REQUEST

Current Zoning: N1-B (neighborhood 1-B), N2-B (neighborhood 2-B)
Proposed Zoning: N1-B(CD) (neighborhood 1-B, conditional), N2-B(CD) (neighborhood 2-B, conditional), and CG(CD) (general commercial, conditional)

Approximately 80 acres located on the east side of East Independence Boulevard, north of Hayden Way, and west of Sam Newell Road.

PLANNING STAFF REVIEW

**RZP-2023-069
 REZONING**

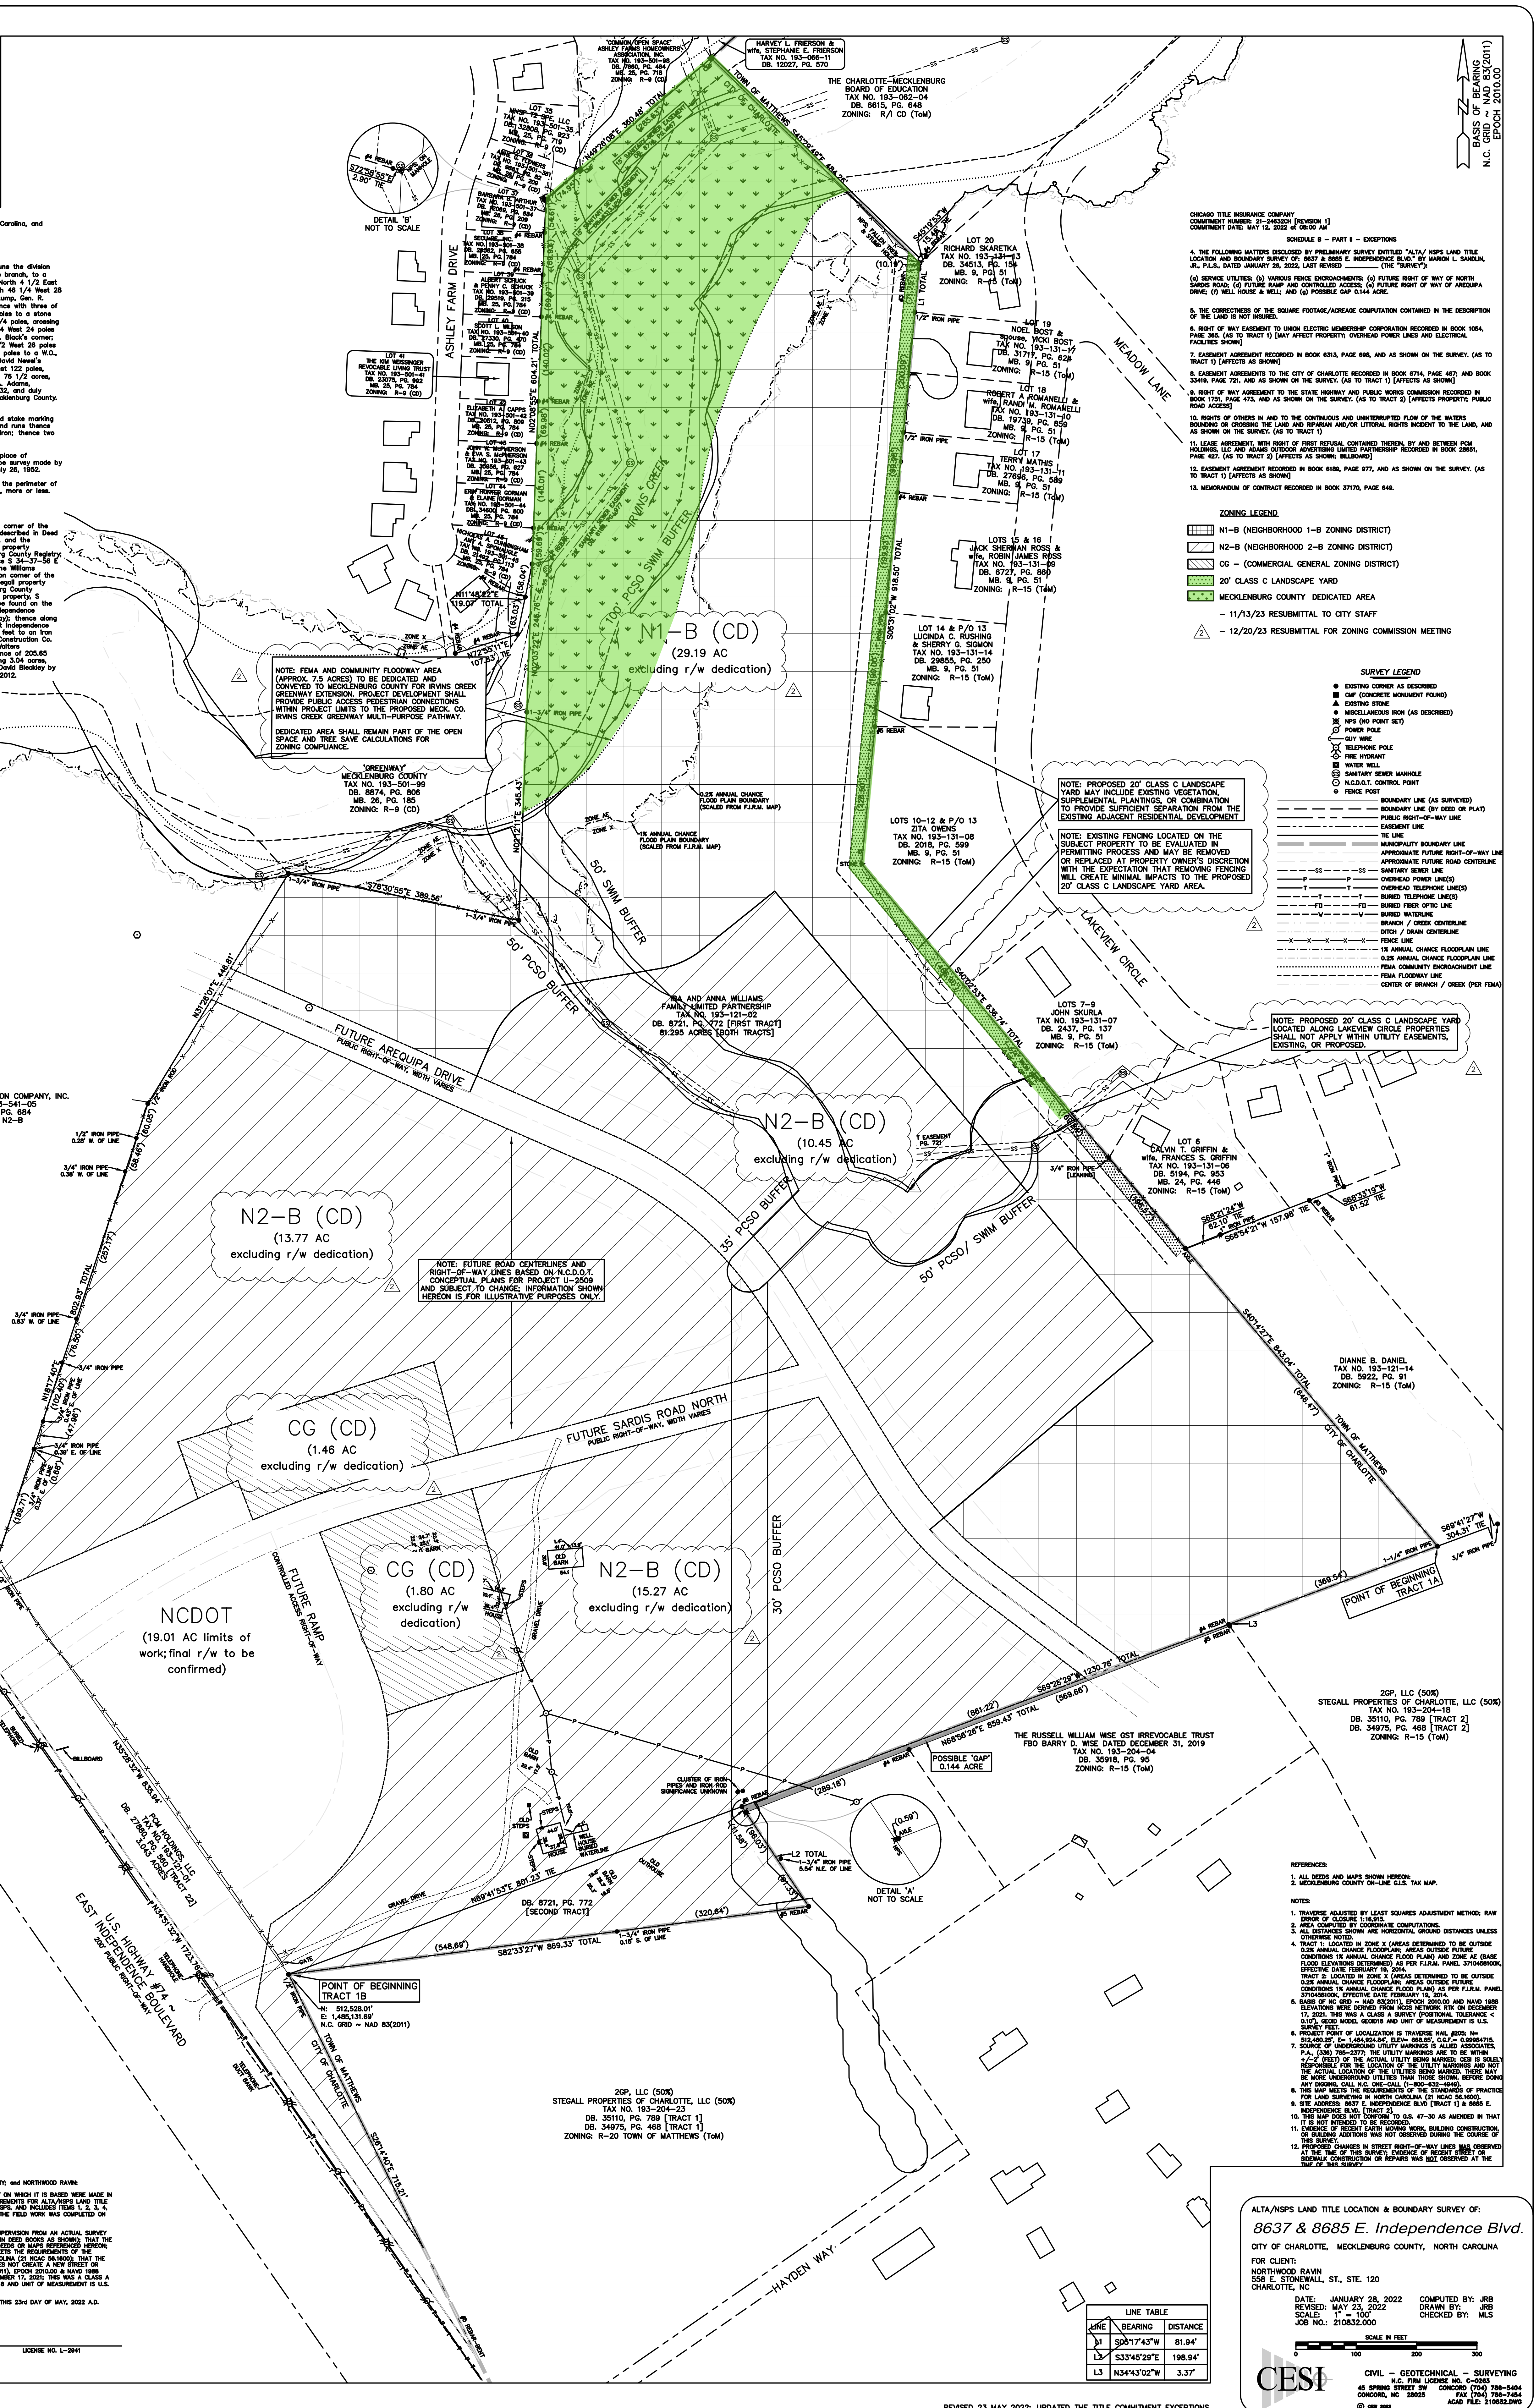
1. MCPR requests minimum of 3.5 acres to be dedicated and conveyed to Mecklenburg County for a future local park. This requested park land shall be adjacent to a public right-of-way for access and is conducive for the development of the typical amenities found in a local park and cannot include tree save parcels or stormwater BMP's. Ideally, the proposed park land shall be adjacent to the requested greenway access easement.
2. The dedication note should read: "...to be dedicated and conveyed to Mecklenburg County for Irvins Creek Greenway..." Easements are conveyed to Mecklenburg County, not to the Park and Recreation Department. The creek is Irvins Creek, not Irwin Creek.
3. The notes should be revised to reference "Irvins" Creek.

4. Label zoning of abutting properties.
5. A portion of the proposed vegetative setback crosses an existing sanitary sewer easement.
6. Please define what is meant by a vegetative setback and provide a planting schedule based on the landscape yards in the UDO.
7. The notes reference a 20-foot vegetative setback and a 20-foot Class C buffer. Please clarify which standard is being used and ensure labeling and notes reflect correct. Please note the Charlotte UDO references landscape yards as a standard.
8. Please remove references to buffers and use the UDO terminology of Landscape Yards.
9. There appears to be a fence along portions of the property line. Please confirm if this is existing to remain, be removed, or proposed.
